Re: PA22-023- Brodie Rezone PRD – Technical Review 2

SUBJECT: PA 22-023 – Brodie Subdivision

SP-01
 SHEET 4 OF 14

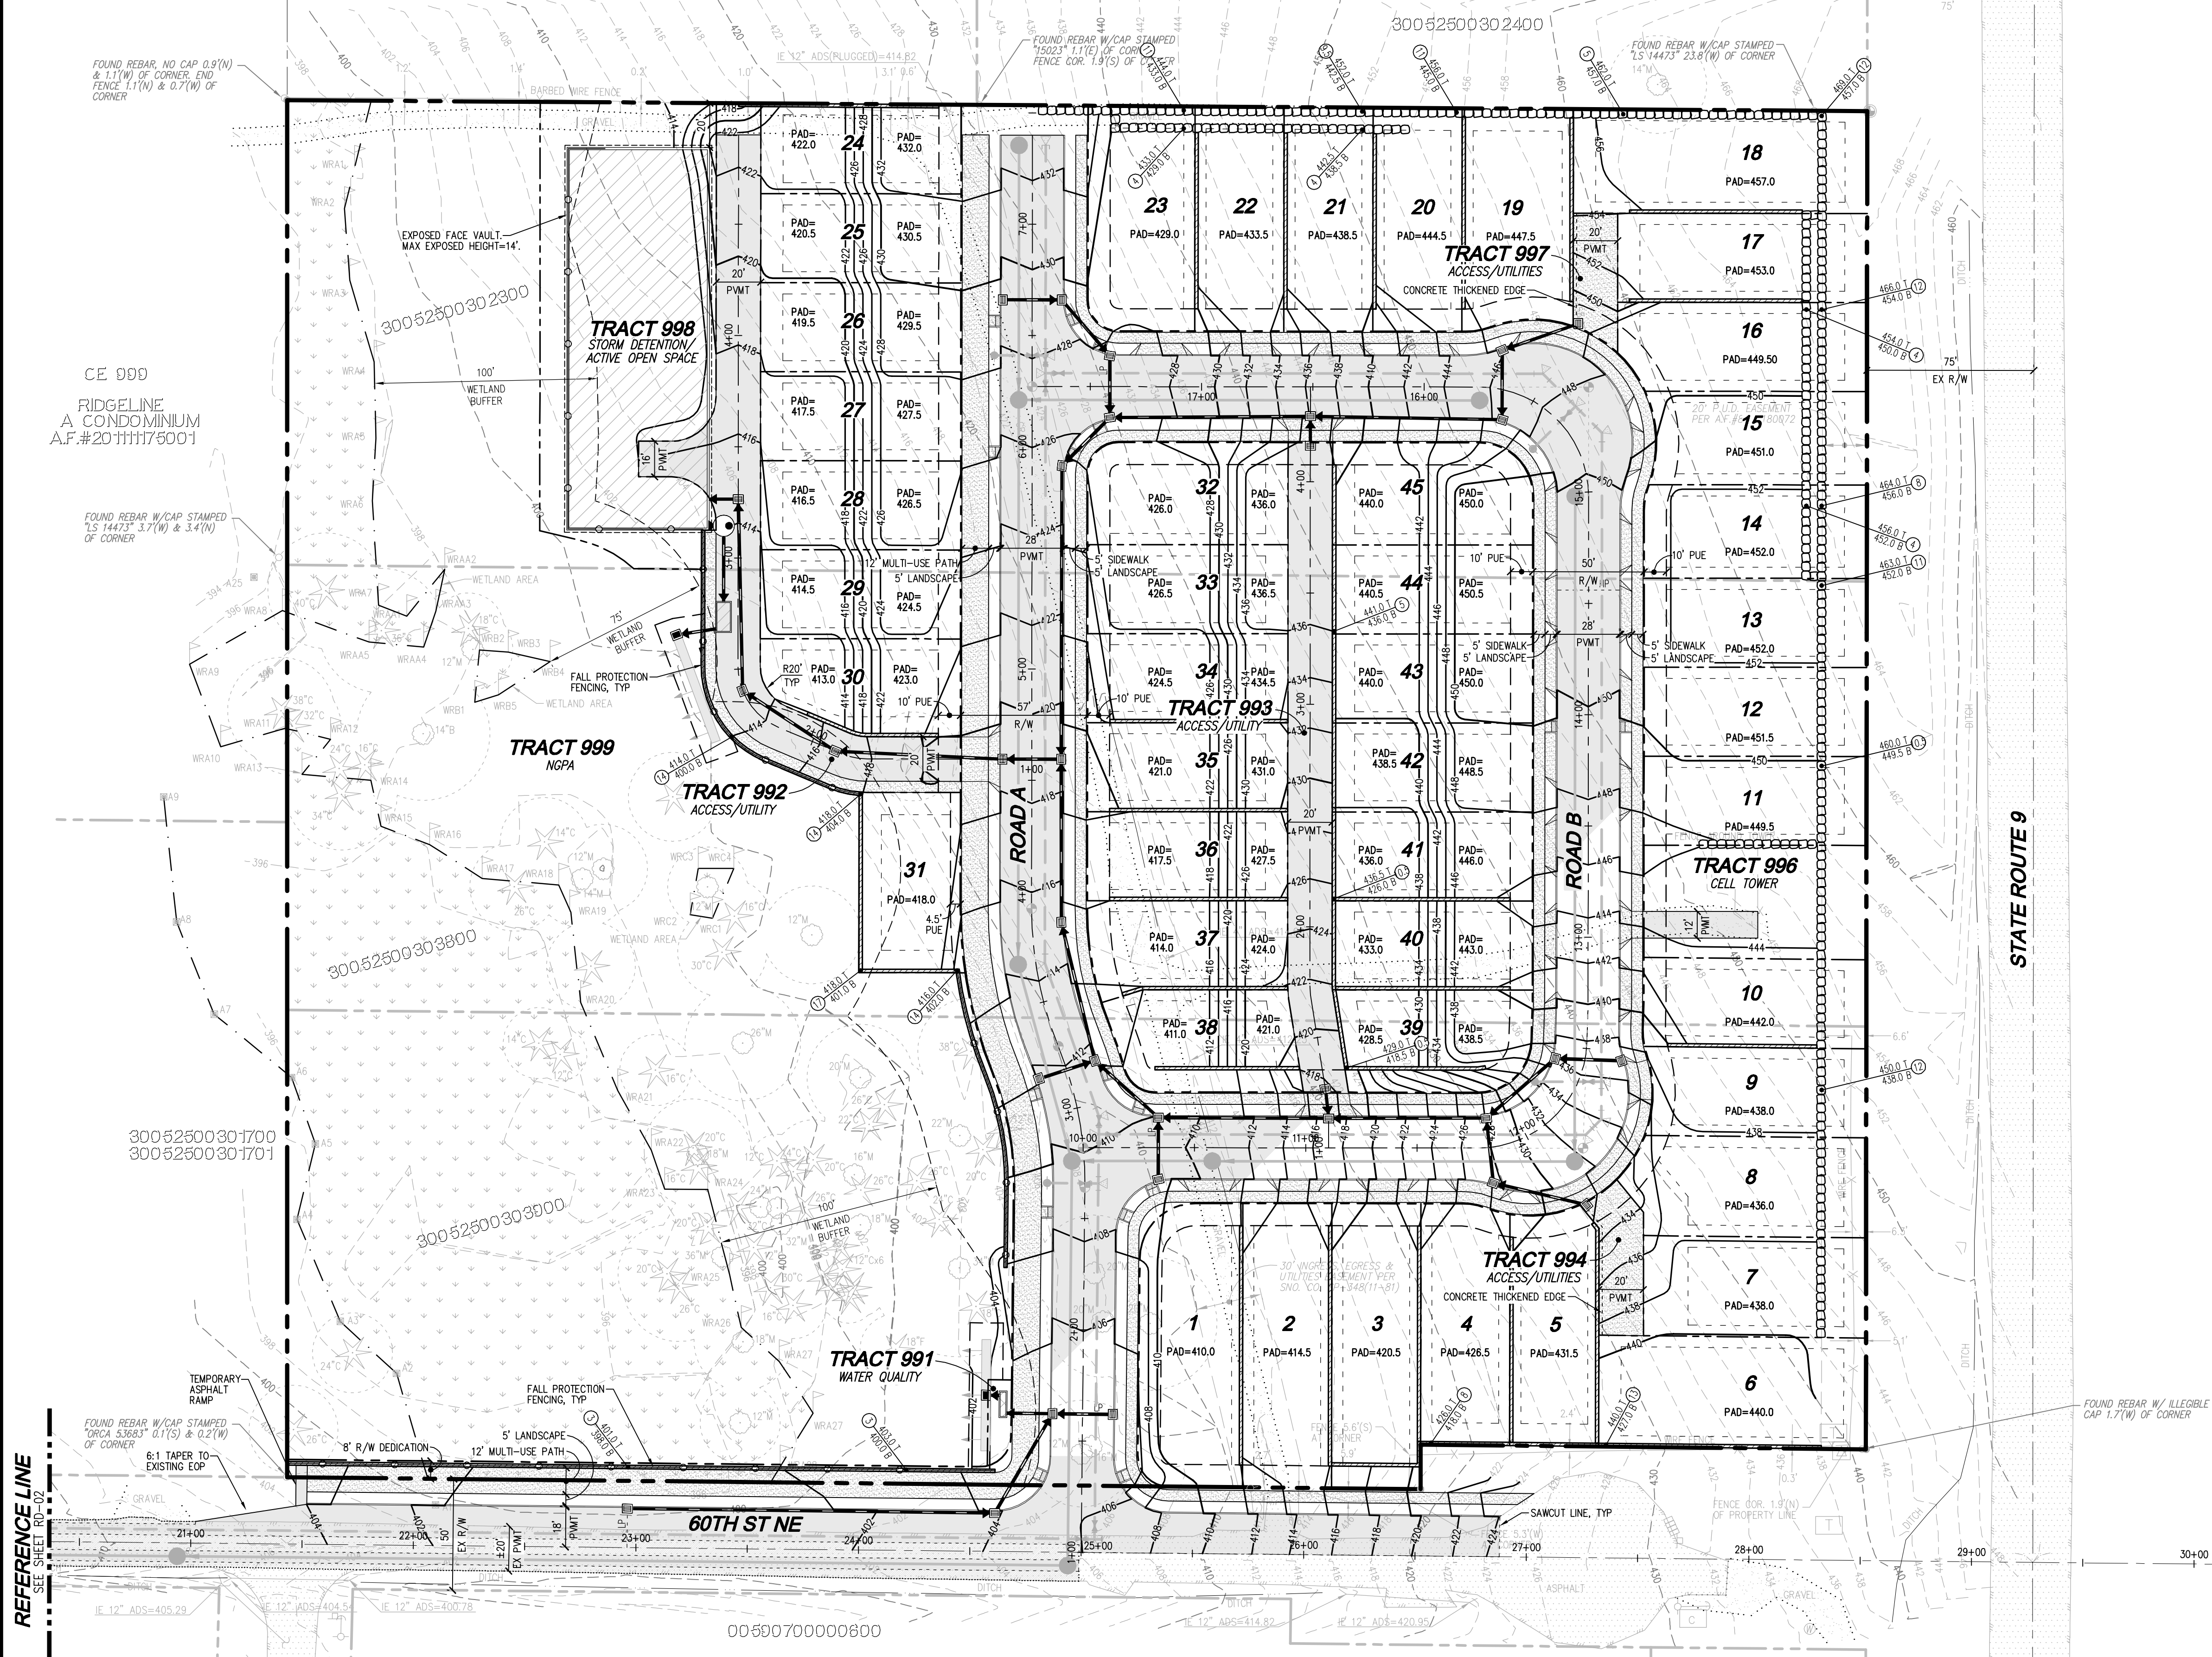
- 3.1. As proposed, Lots 1 – 5 would not meet this requirement. Reconfigure lots to alleviate rear yards abutting 60th Street NE and demonstrate how pedestrian access can be provided from the front façade of the dwelling unit to the public sidewalk on 60th Street NE.

- 3.2. Staff may be amenable to Lots 4 and 5 not being oriented toward 60th Street NE, however, a 10 ft. landscape easement with fencing, to be maintained by the HOA, would be required.

LAND PRO GROUP, INC.
BRODIE PLAT
 PRELIMINARY ROAD, GRADING AND STORM DRAINAGE PLAN

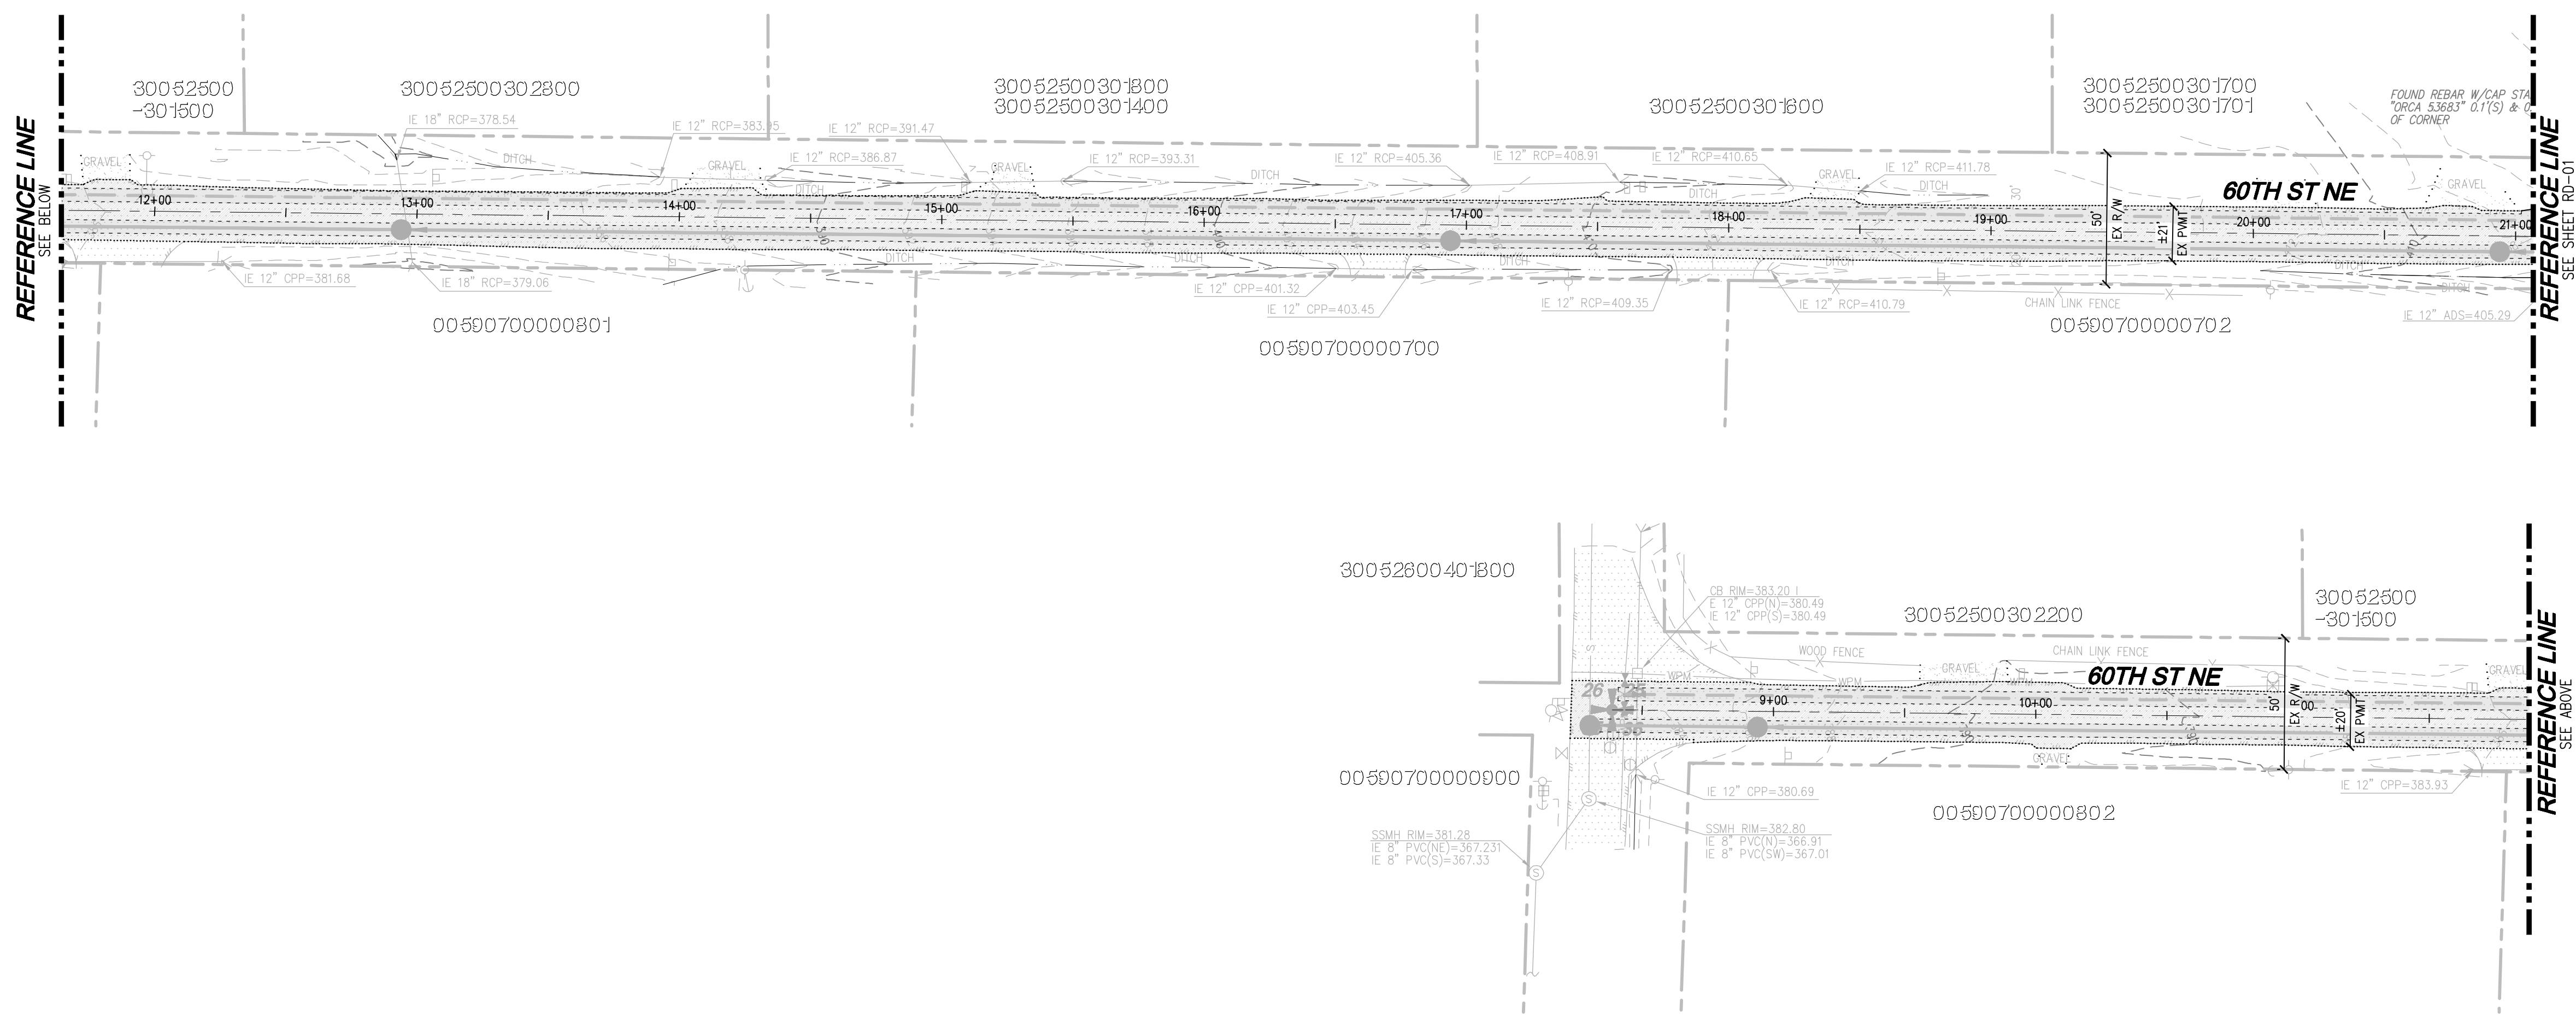
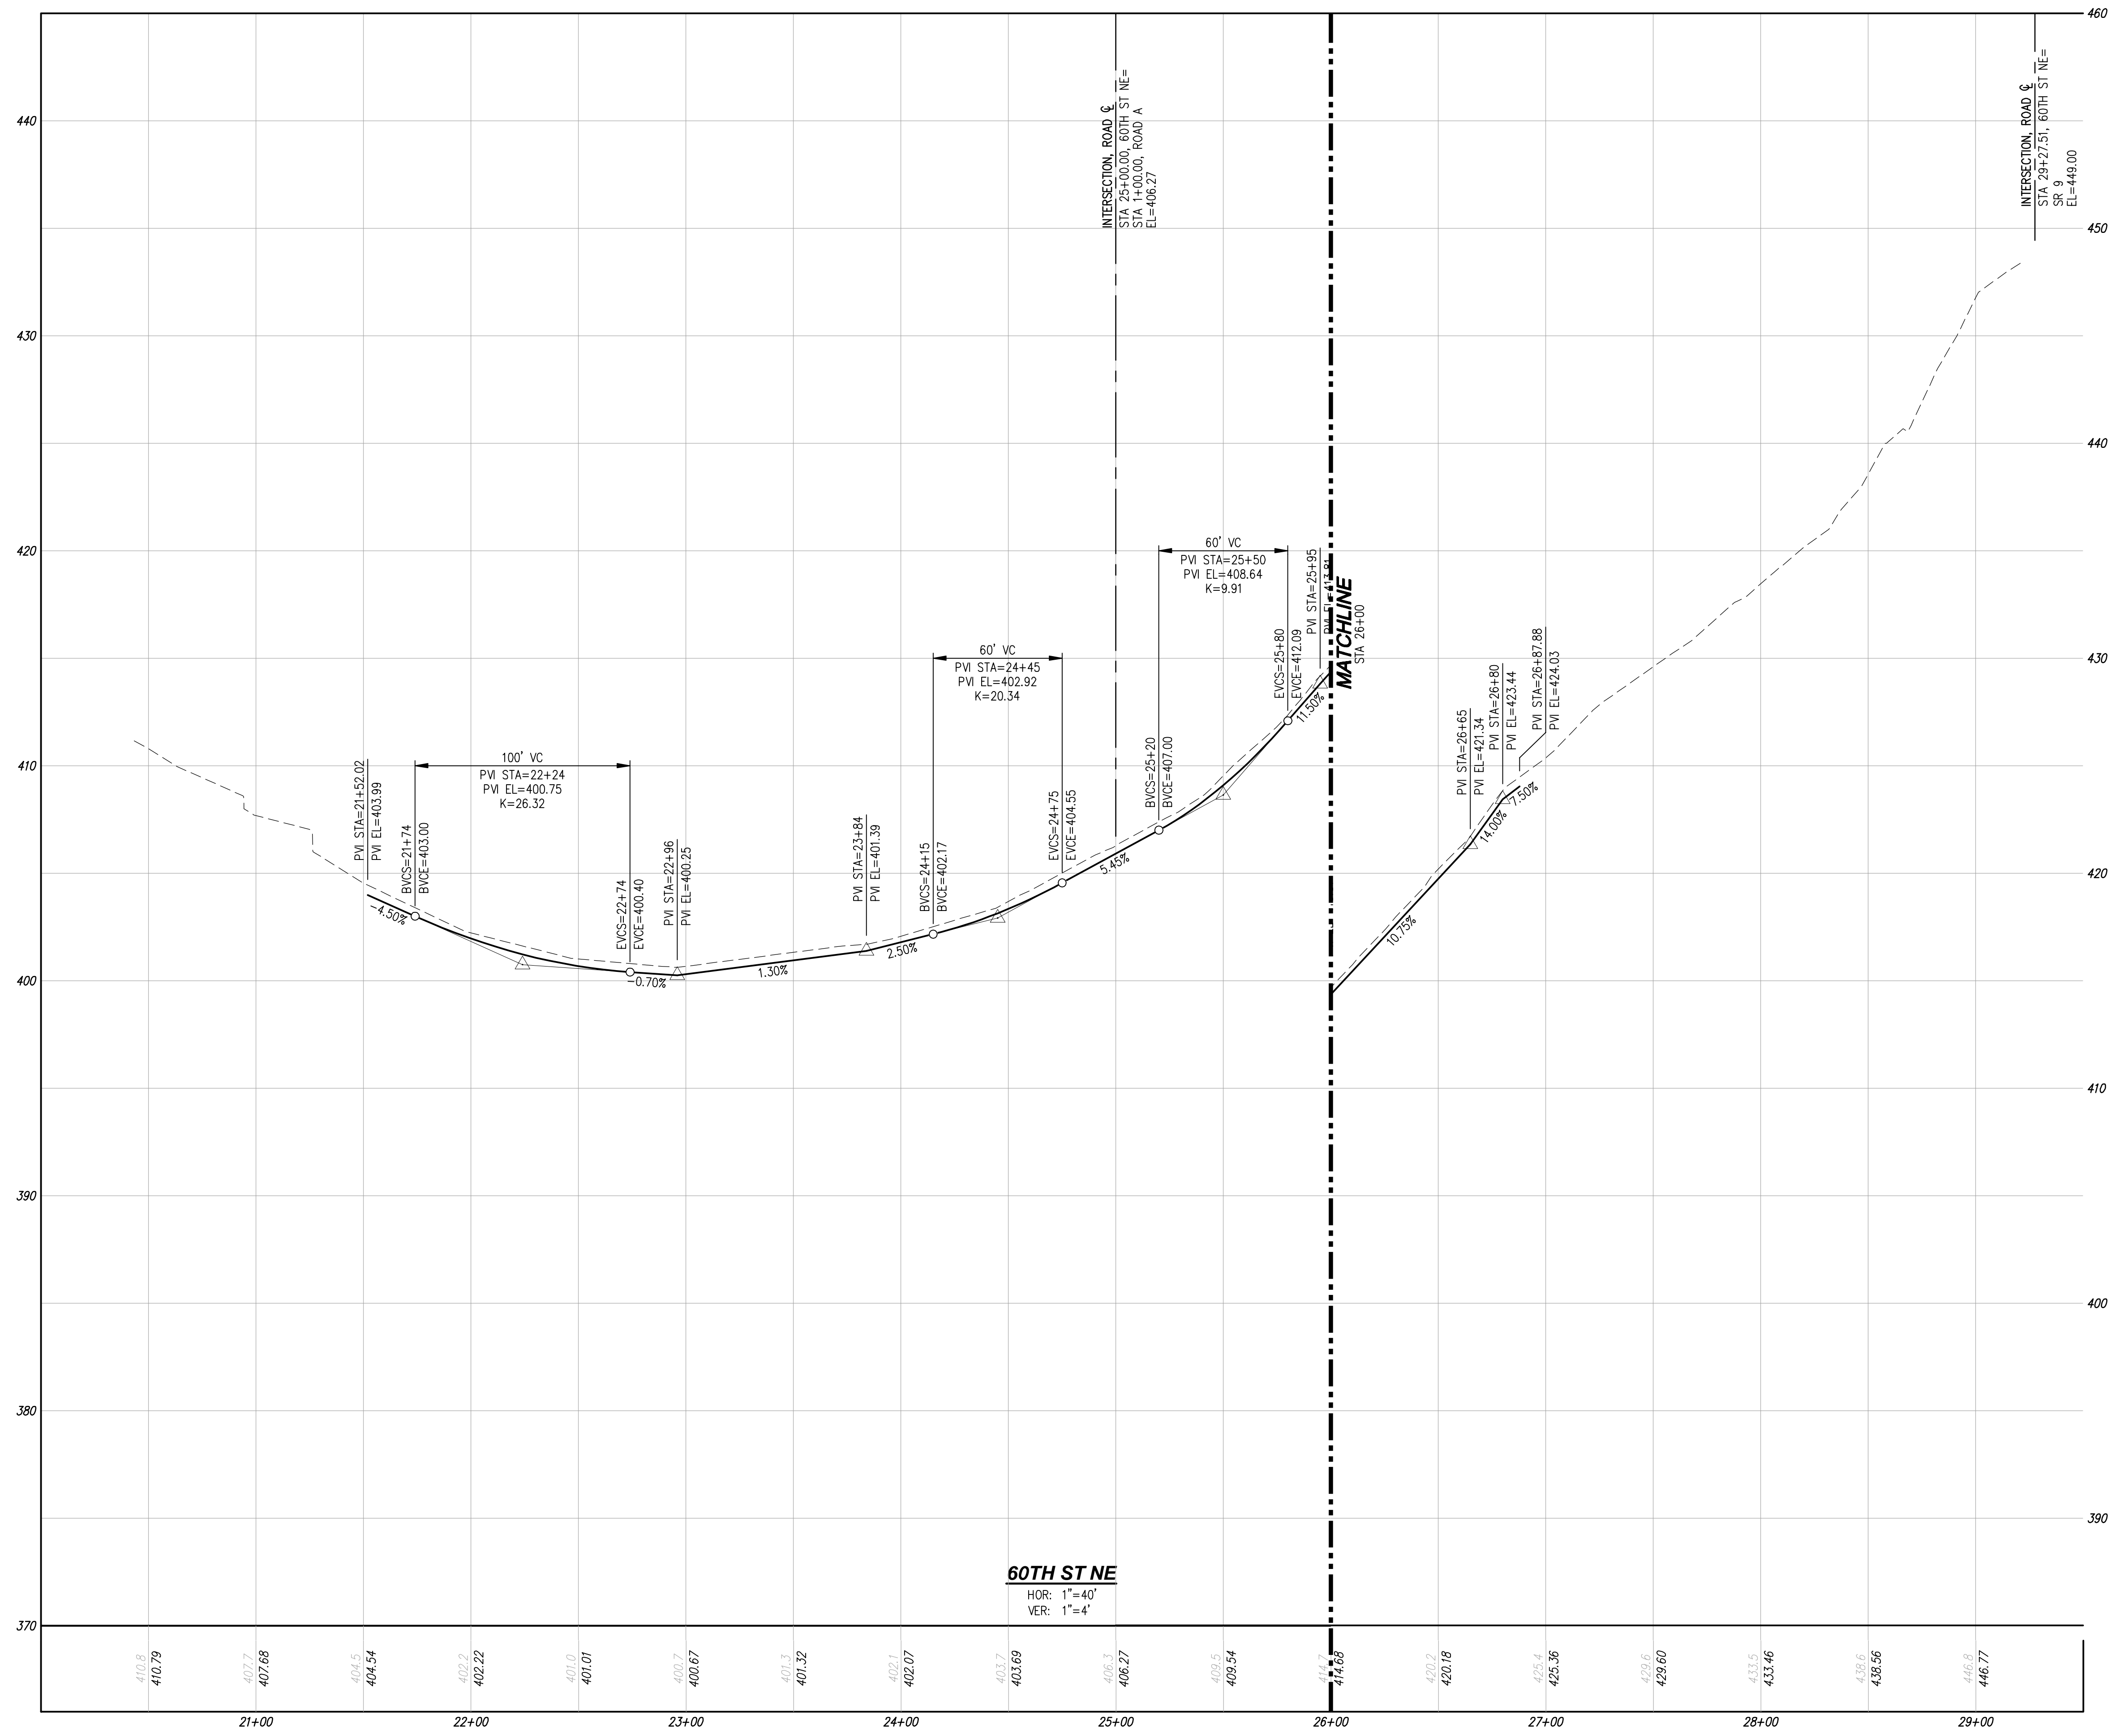
4. Based on Sheet GR-01, some of the sections of the proposed retaining wall will exceed 4 ft. in height and are positioned along the right of way. Being as there are residences across 60th St NE, the wall sections exceeding 4 ft. are required to be terraced.

Staff is willing to accept other remedies to detract from the overall wall massing impacts to adjacent properties other than requiring the walls to be terraced.

- 4.1. This comment may be remedied with Comment #3 above.
